Derby Cycling Group,
c/o 126, Station Road,
Mickleover,
Derby,
DE3 9FN

Date: 4th November, 2019.

Your Ref: **A38 Junctions Interested Party Written Representation from Derby Cycling Group**

Appendix 1: Derby Cycling Group NMU Checklist

Drawing Title  
FIGURE 2.7  
LITTLE EATON JUNCTION  
GENERAL ARRANGEMENT

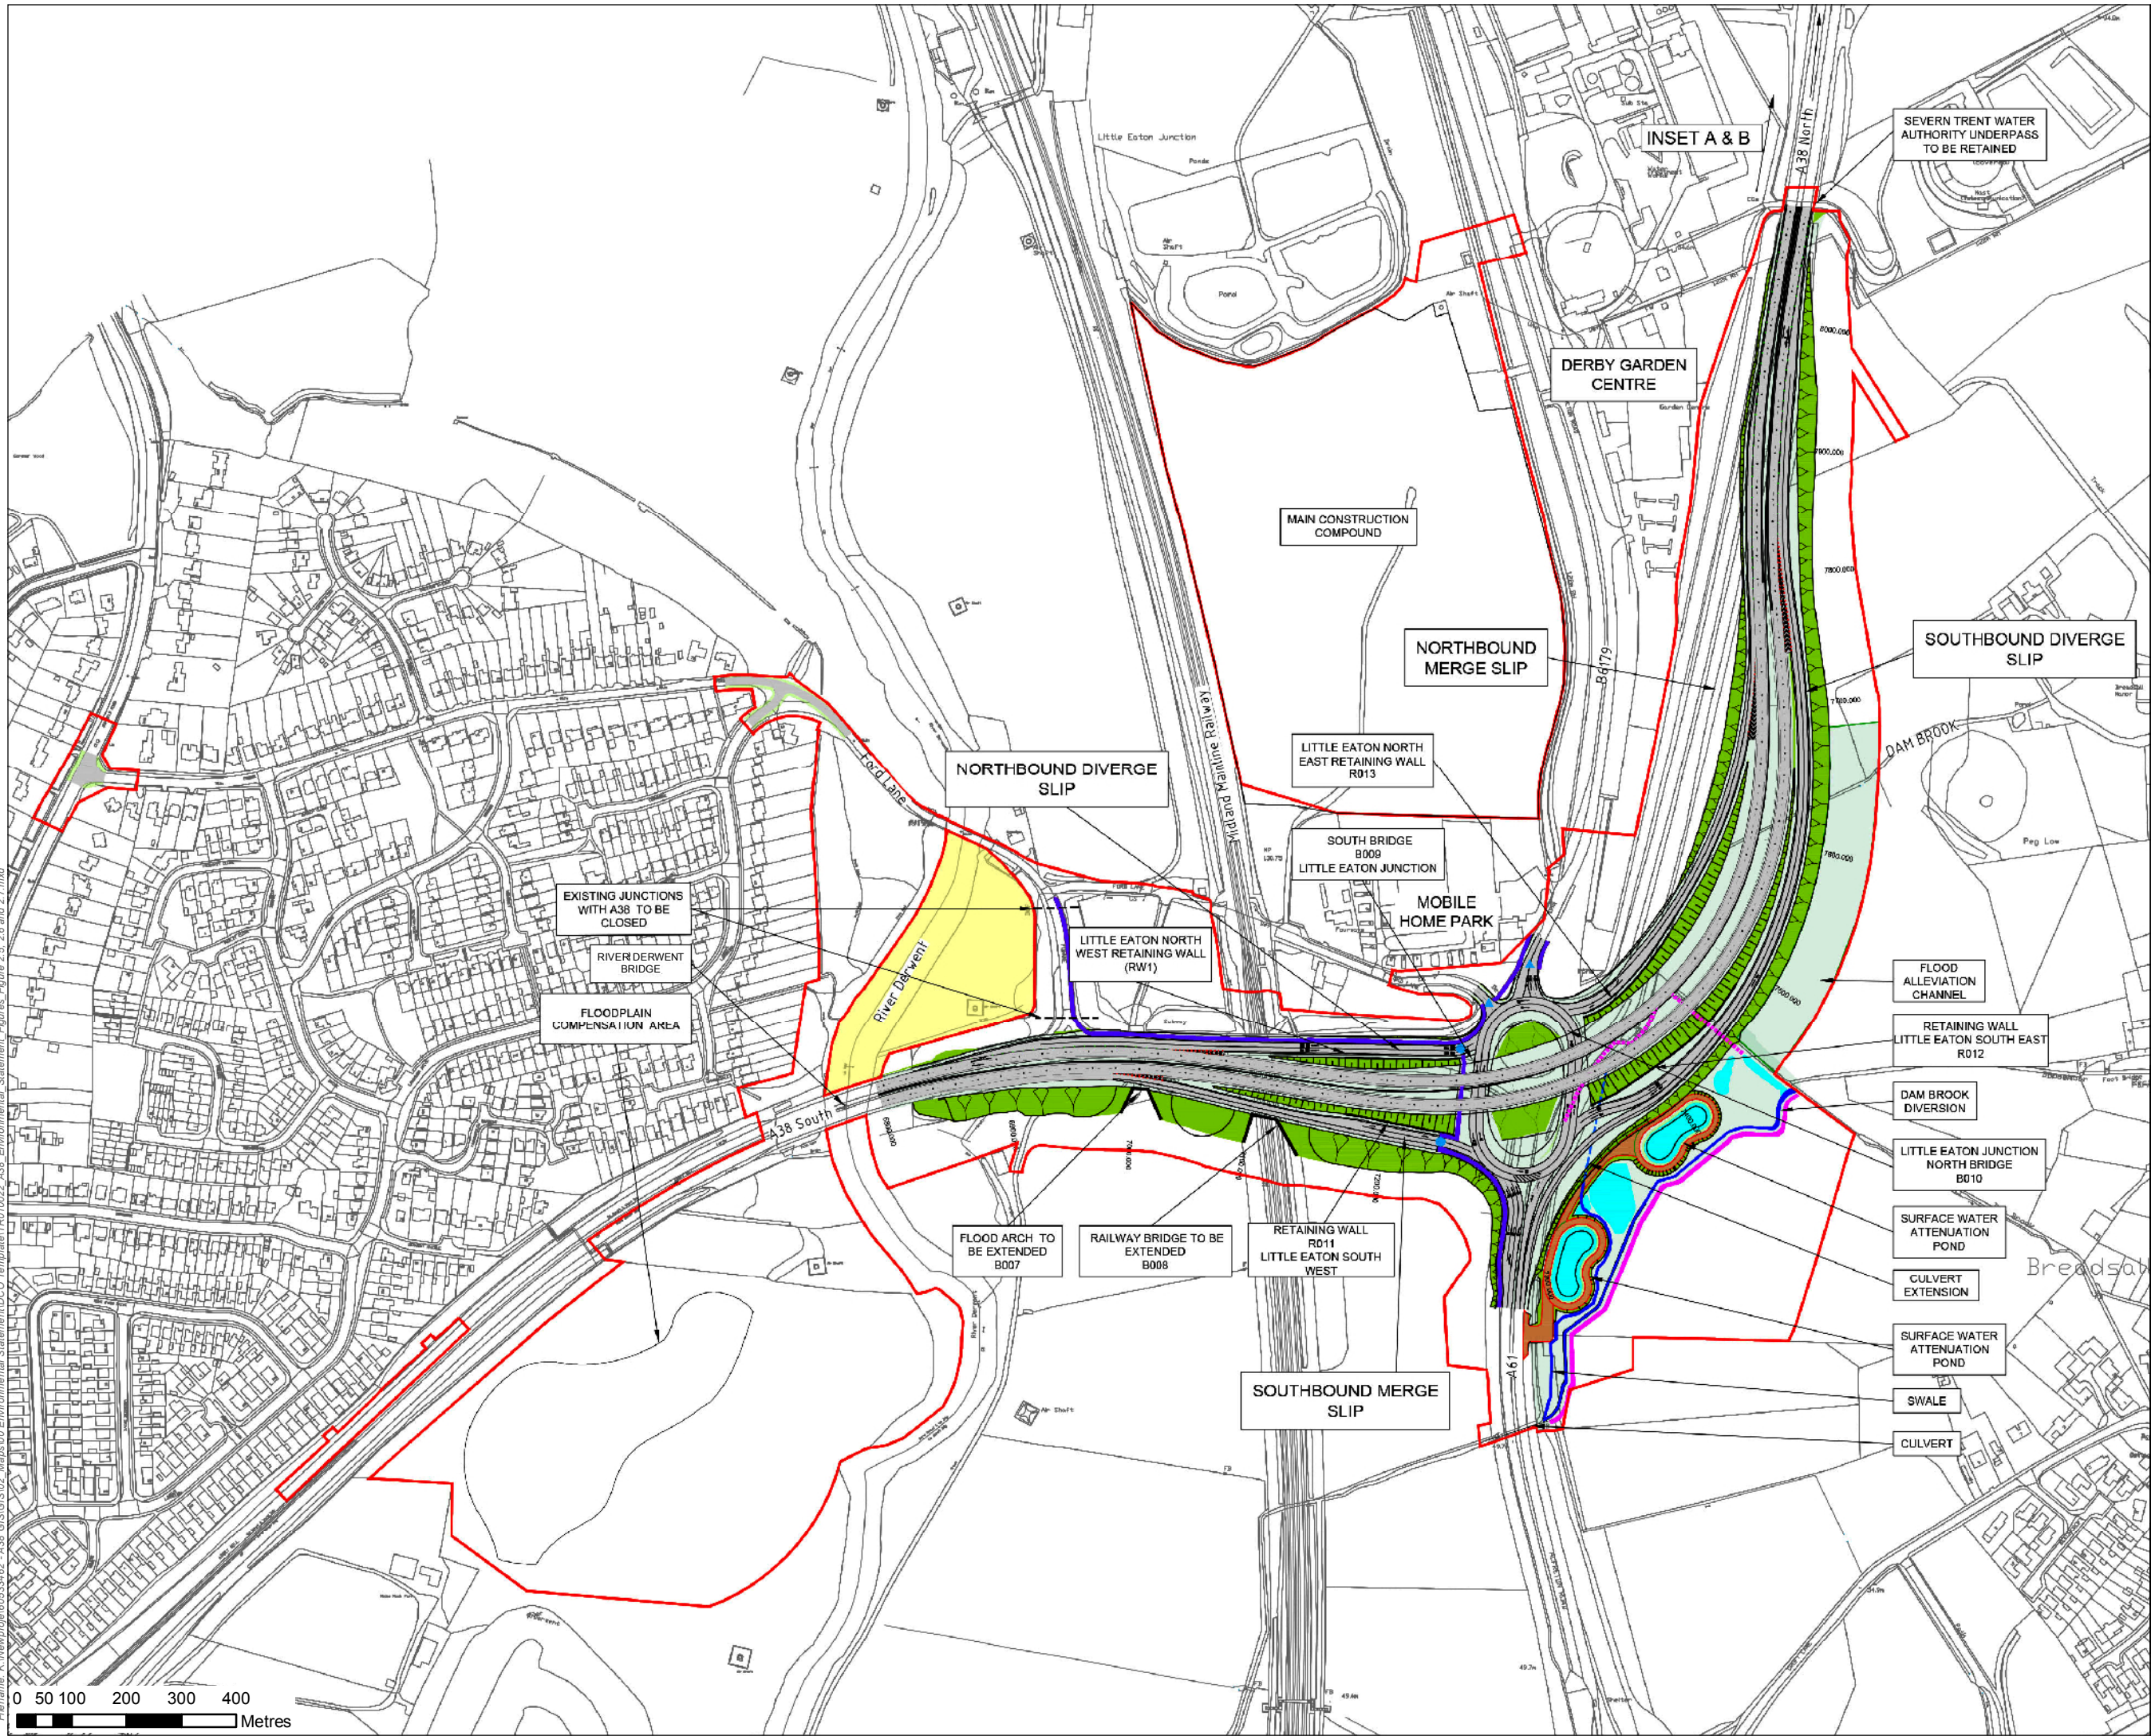
4. Little Eaton/A61 Junction			
	Retain signal controls on the crossings of the what will become the A38 slip roads.		Uncontrolled crossings are not appropriate because the desire is for children, their parents and families to feel safe using these off-road routes.
	Ensure parking at the cut-off end of Ford Lane cannot block access to the cycle and pedestrian paths.		We need to see designs to prevent this.
	Create a segregated, shared use path leading south along the A61, away from Little Eaton island.		No commitment to segregation
	Create a NMU priority crossing over the entrance to Ford Lane near Starbucks, and across the entrance to Starbucks its self.		Outside of plan area; this needs a coordinated plan with Derbyshire County Council
	The uncontrolled crossing previously proposed over the A61 immediately south of the Little Eaton island has been removed from the plan; it needs to be replaced with a signal controlled crossing further towards Pektron Island, to replace the existing, dangerous, uncontrolled crossing towards Croft Lane and Breadsall village.		The project team state that this crossing is planned, but it will be delivered separately from the A38 Junctions project by Highways England - we need to see the details of this.

The underpass beneath the A38 for NMUs travelling from Ford Lane (West) towards Darley Abbey by the river, should be retained and ideally enhanced. The facilitation of the Derwent Valley Cycleway (DVC) is a primary importance in this area.		Any further works to develop part of the DVC would be very welcome.
	Associated with the motor traffic improvements, the widening of NCN 54 southwards from Little Eaton Island to Pektron Island (especially from the end of the dual carriageway) is needed to encourage more cycle journeys along this route. There needs to be: <ul style="list-style-type: none"> . A segregated shared path all the way from Little Eaton Island to Pektron Island. . A parallel crossing at the end of Alfreton Road outside Pektron to allow cyclists to regain access to the road in safety . A cycle access point from Alfreton Road onto the cycle path, avoiding cyclists slowing in traffic to access the path. 		NCN54 path between Pektron Island towards Little Eaton Island has been improved with widening of the path itself, but has not been segregated and the access/exit at Alfreton Road has not been upgraded.

EITHER: The existing shared path on the north side of the A38 between Little Eaton junction and Ford Lane is extremely narrow and needs to be widened to a good national standard.		The path is ridiculously narrow because of barriers protecting the rail bridge parapet, which have been placed on the NMU path. Extra space can be gained utilising the area currently occupied by the Ford Lane slip road, and if the A38 exit slip road was to be designed as a single lane at the point where it crosses the rail bridge (only opening out to two lanes once over the rail bridge) then there would be enough space for a segregated route.
	OR: If the shared path on the north side of the A38 over the railway between Little Eaton junction and Ford Lane is to remain as it is, then a new, segregated cycle/pedestrian path should be created to the south of the A38, connecting the Little Eaton junction with the NMU underpass and then on to Ford Lane.		This would be additional to the path on the north of the A38 (which needs to remain because it provides the most direct route for journeys between Little Eaton and Allestree). Note: This option has been considered and rejected by the project team.
